11th December 2020

Re: SSD 10382 - Demolition of existing buildings and structures; and construction of an 18-storey student accommodation development including 408 beds (comprising of 338 studio rooms, 27 twin studio rooms and 16 single ensuite rooms), communal spaces, on-site bicycle parking, ancillary facilities, and ground floor retail premises.

Premises: 90-102 Regent Street, Redfern

Figure 2.4: Construction Vehicle Access to On Street Work Zones

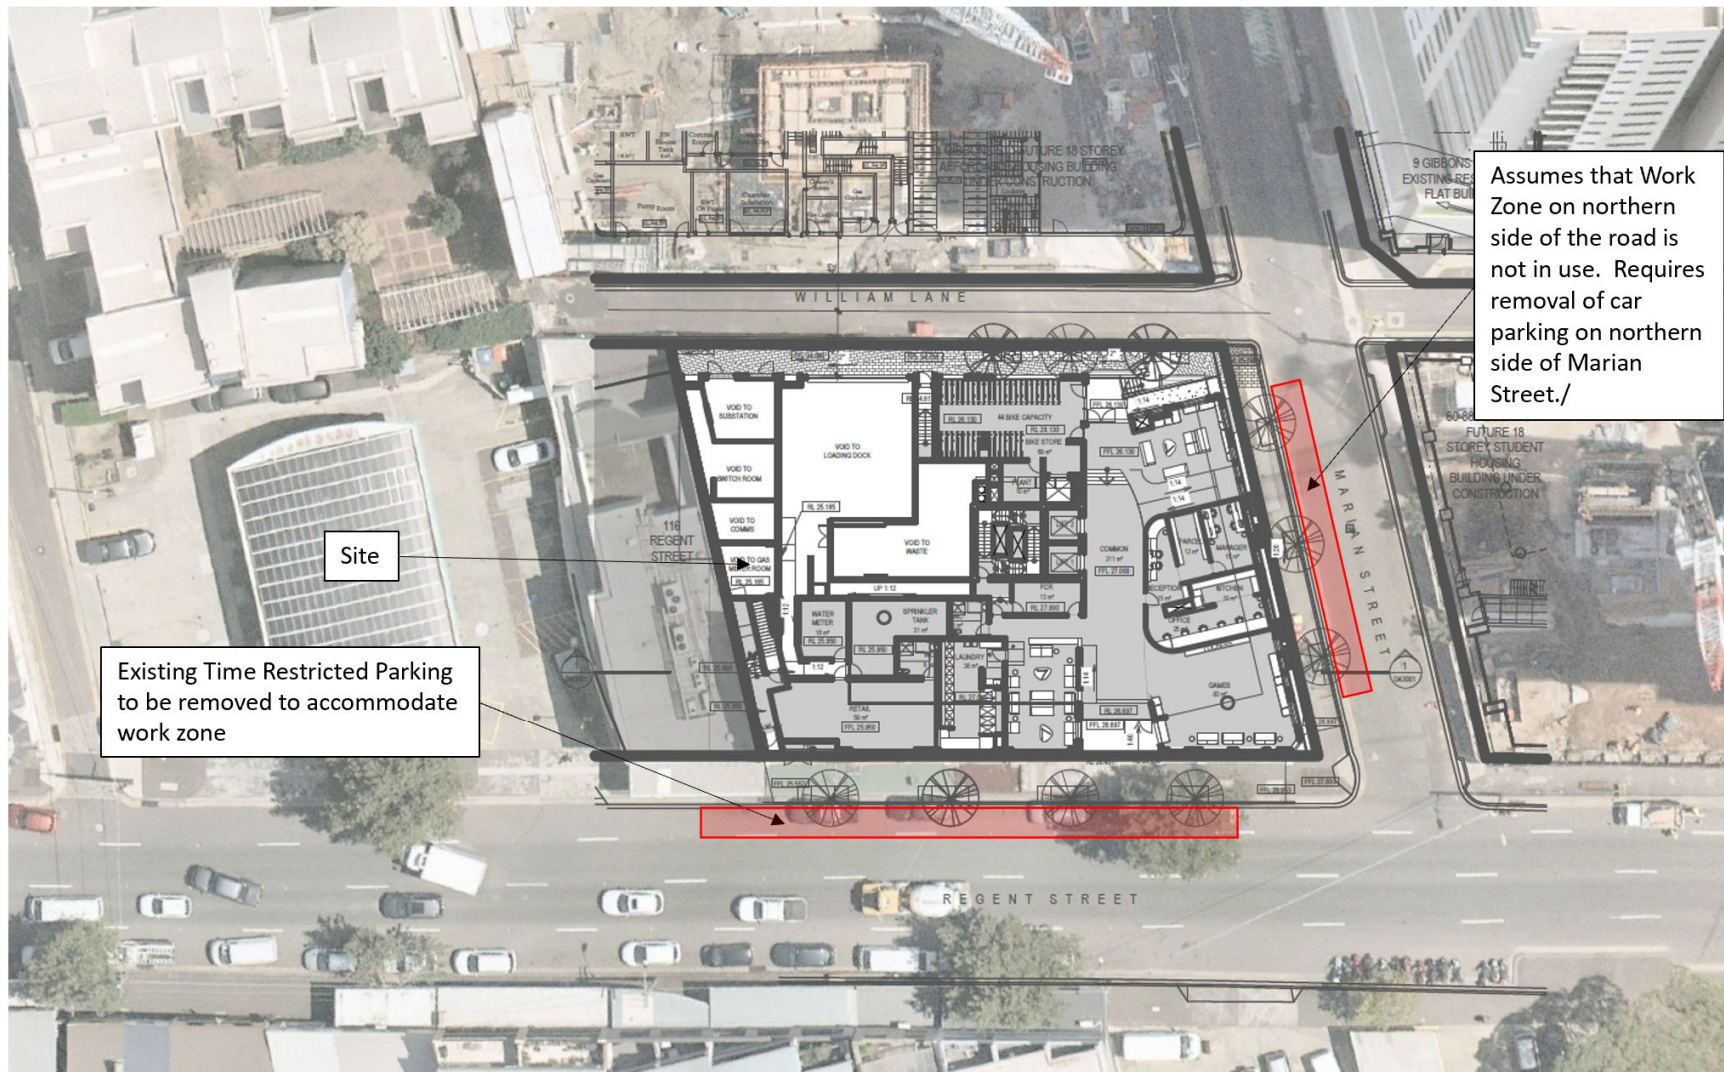
The proposed location of a northern work zone area on Marian Lane as described in the *"Framework Construction Traffic Management Plan"* prepared by The Transport Planning Partnership Pty Ltd will cause foot traffic safety concerns for the local community where construction trucks would cross a high pedestrian area on Regent Street. There is an opportunity to relocate all work zones, loading and unloading activities during construction on the southern end of the site where safety concerns for by-passers would be mitigated.

1 DA GROUND (L1) FLOOR PLAN  
1:200

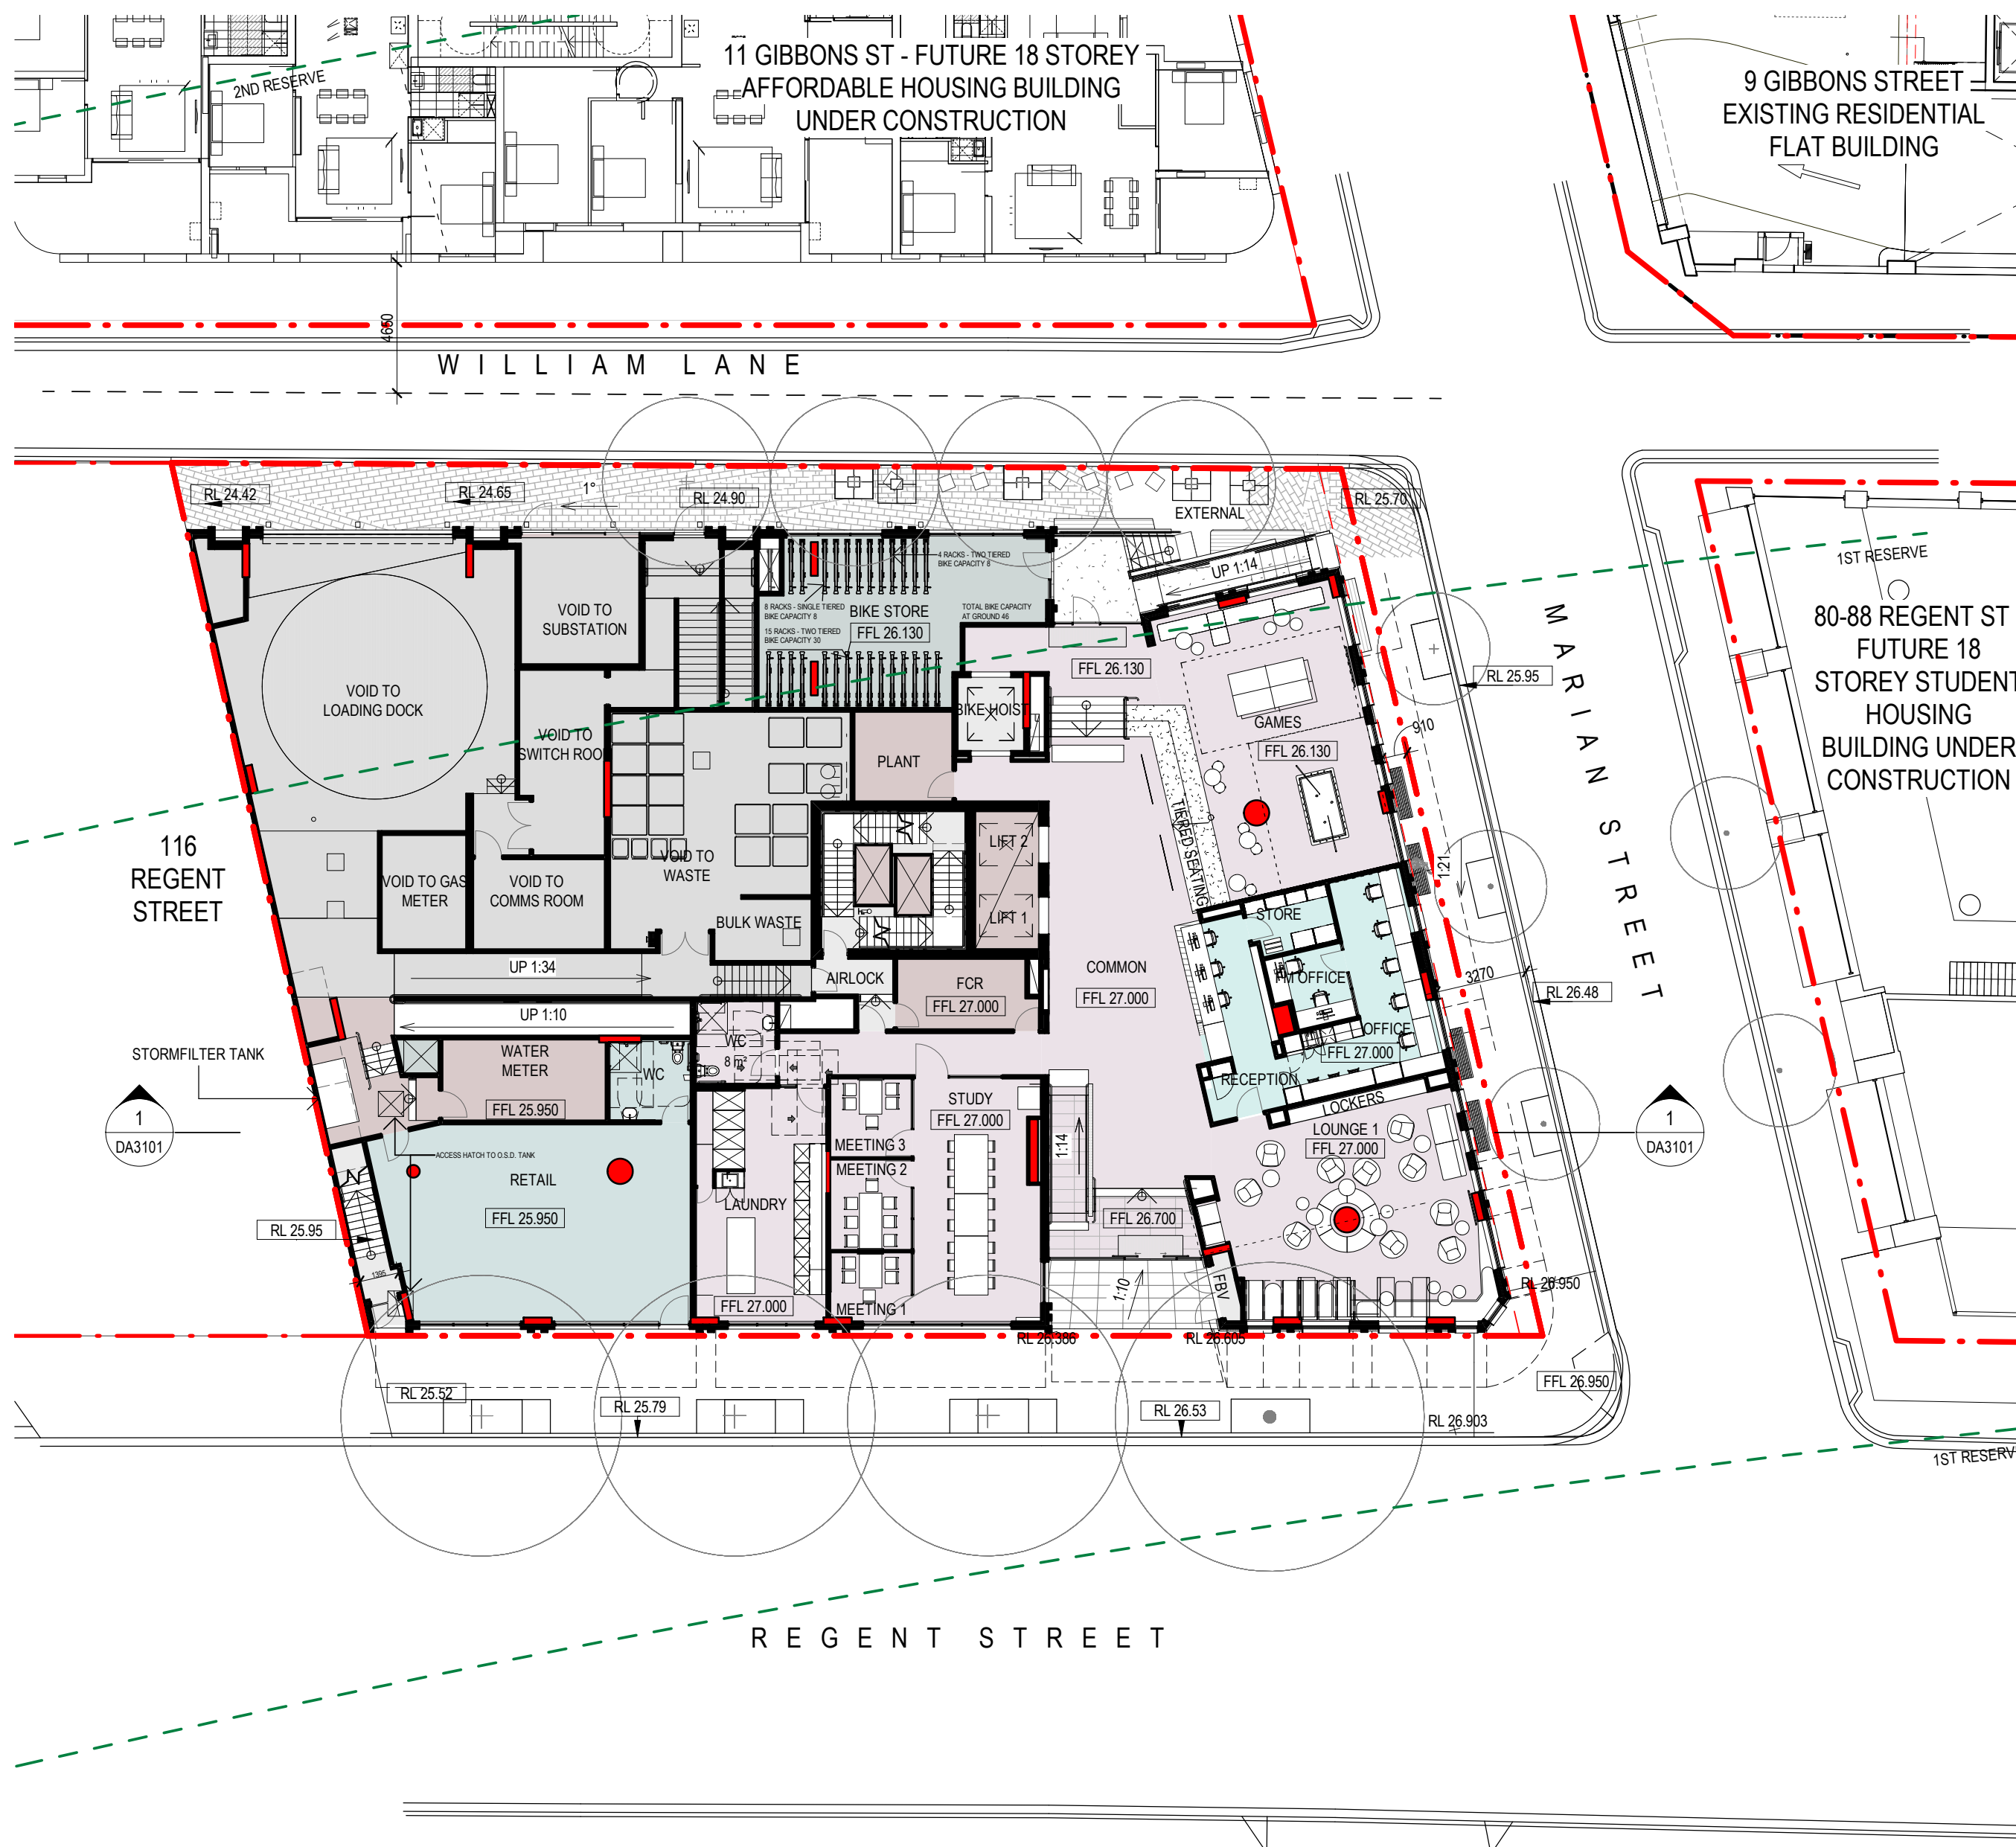
The ground floor of the proposed development lacks commercial and retail activation of the building and does not enhance the amenity of the local community. There is opportunity for the building's communal

spaces on the ground floor to be repurposed into small format retails fronting Regent Street and Marian Lane to ensure the existing village character of small shops, cafes and bars is further developed.

2 LEVEL 2 PLAN  
1:200

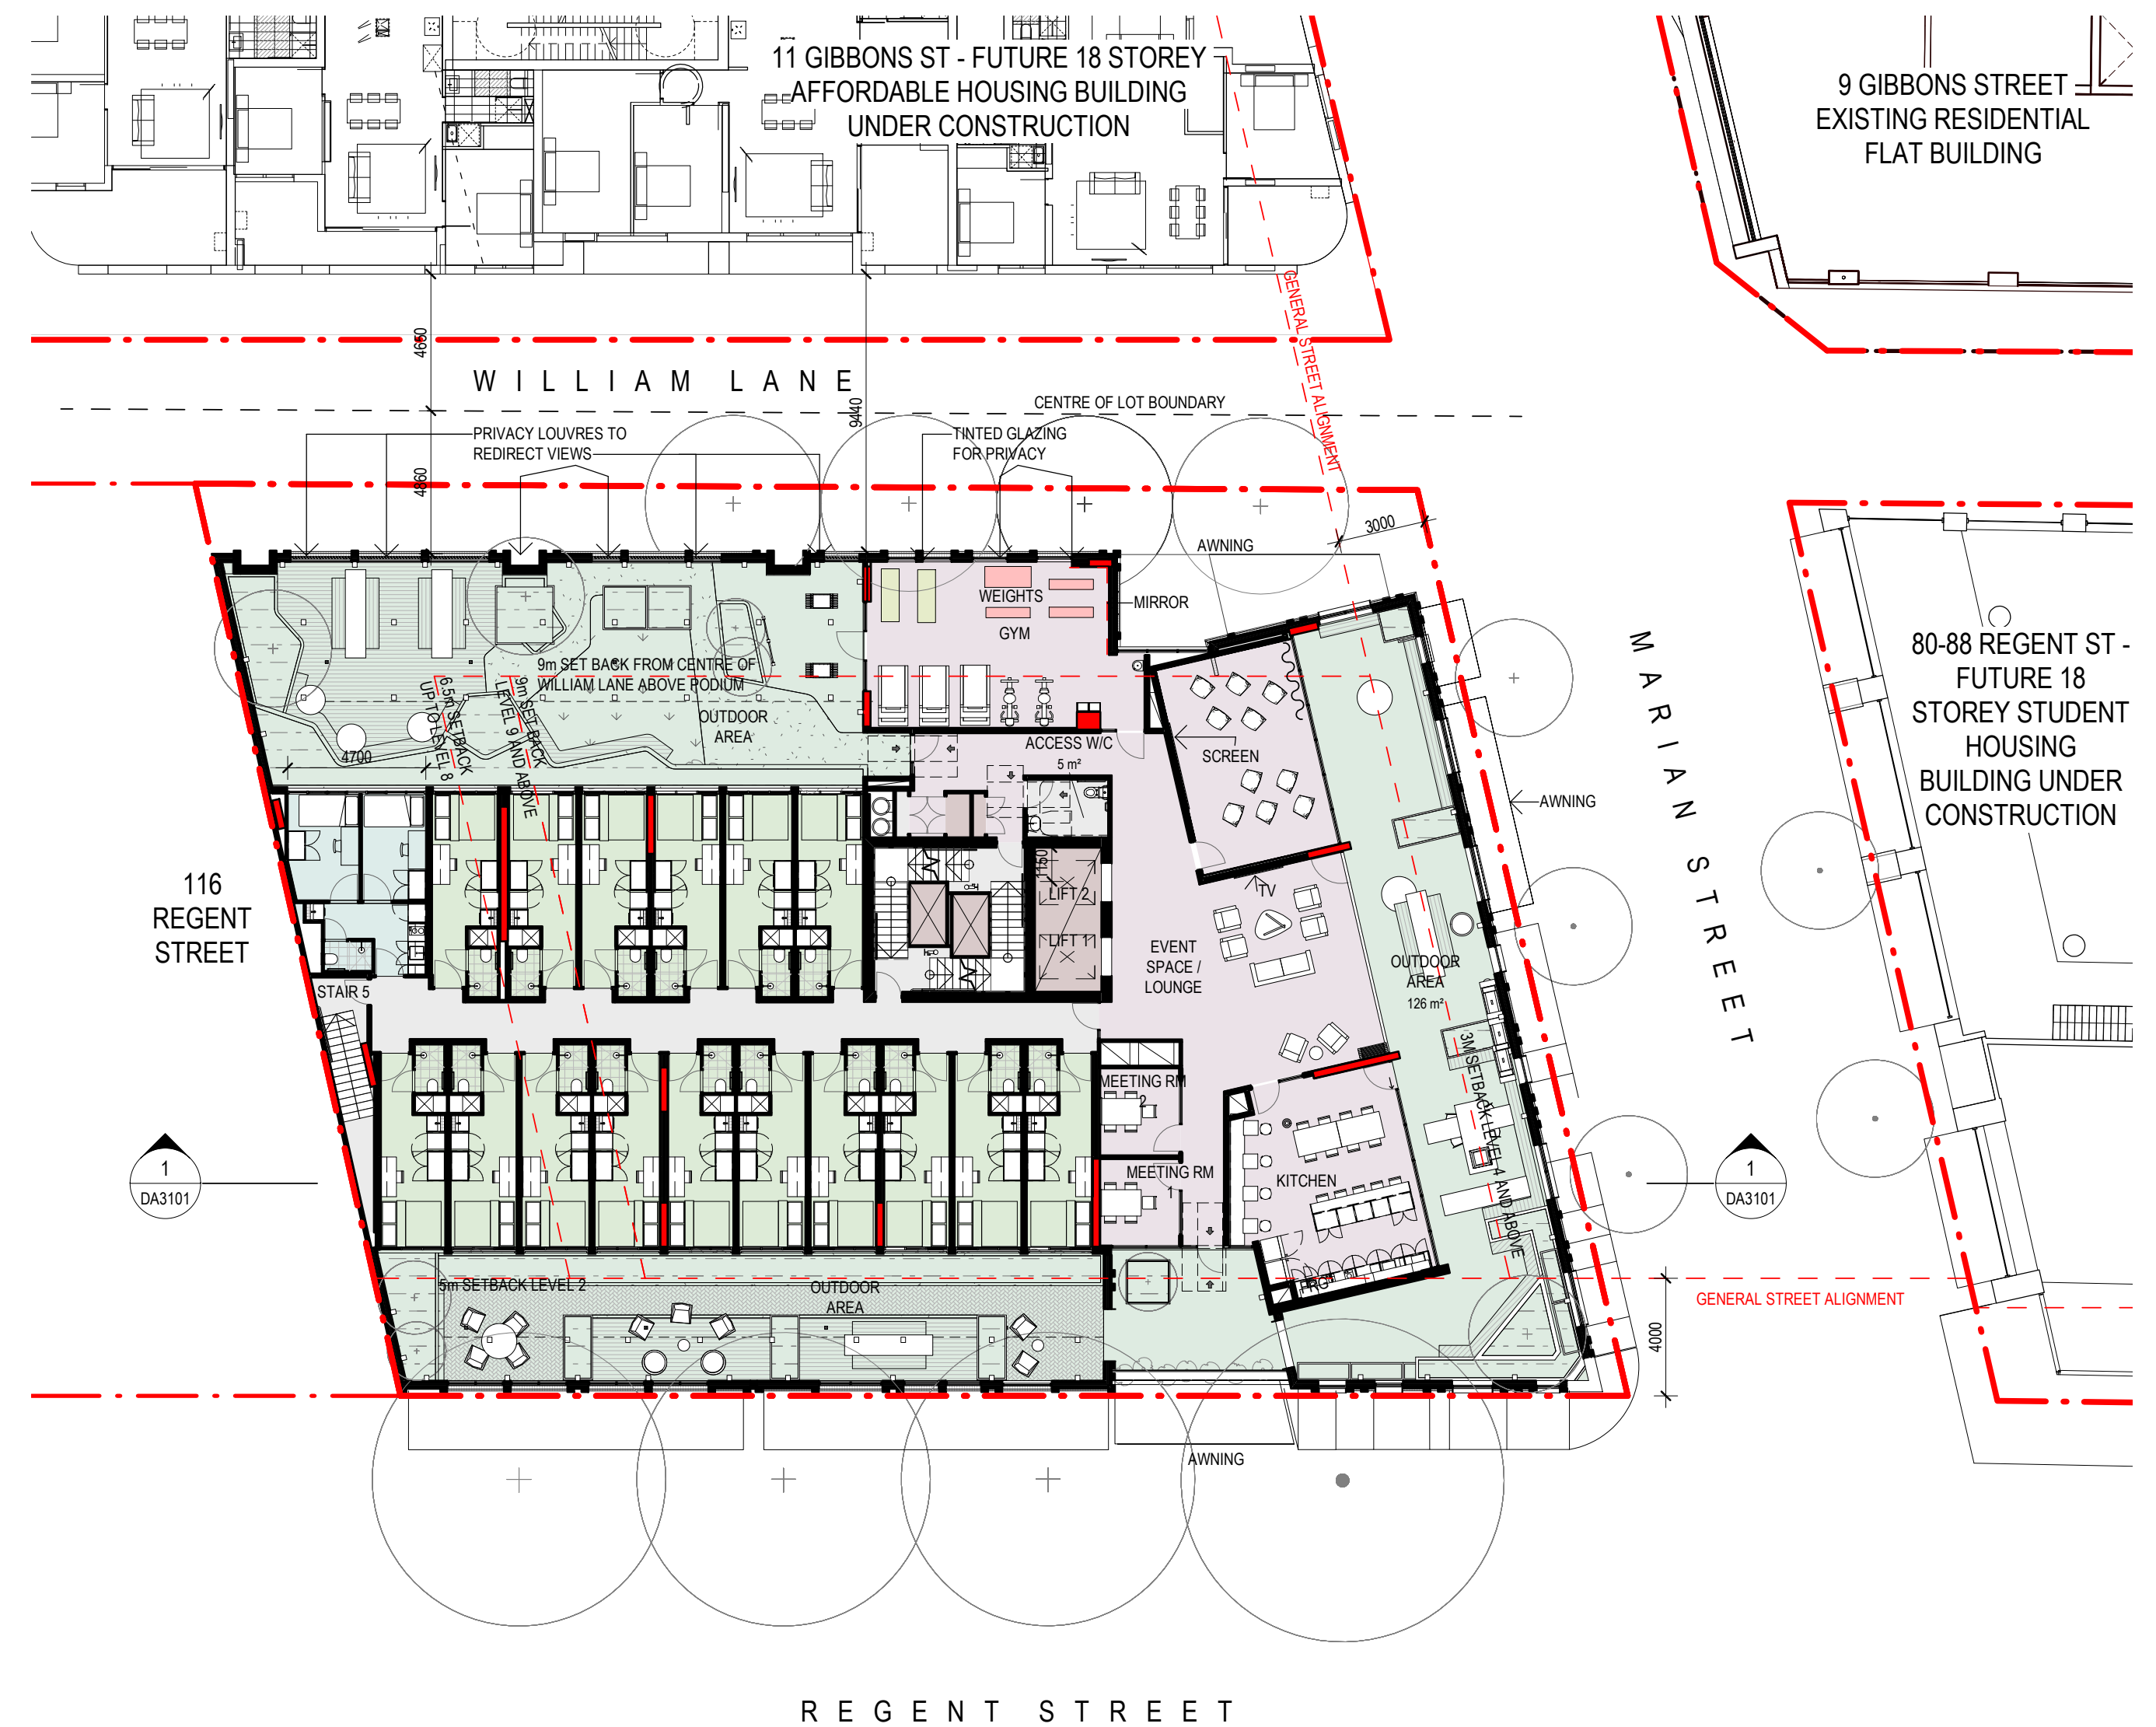
The position of the northern and western facing outdoor areas on Level 2, immediately facing our neighbouring property at 80-88 Regent Street is highly intrusive and will result in loss of privacy for our residents as terraces will allow direct viewing into our residents' bedrooms.

The outdoor areas on Level 2 will cause noise and disturbance to all surrounding properties. If an outdoor area is to be provided, a passive recreation area on the rooftop of the building would be more appropriate, with a management regime in place to ensure it is used appropriately in terms of activities, hours of use and maximum number of persons at any one time.
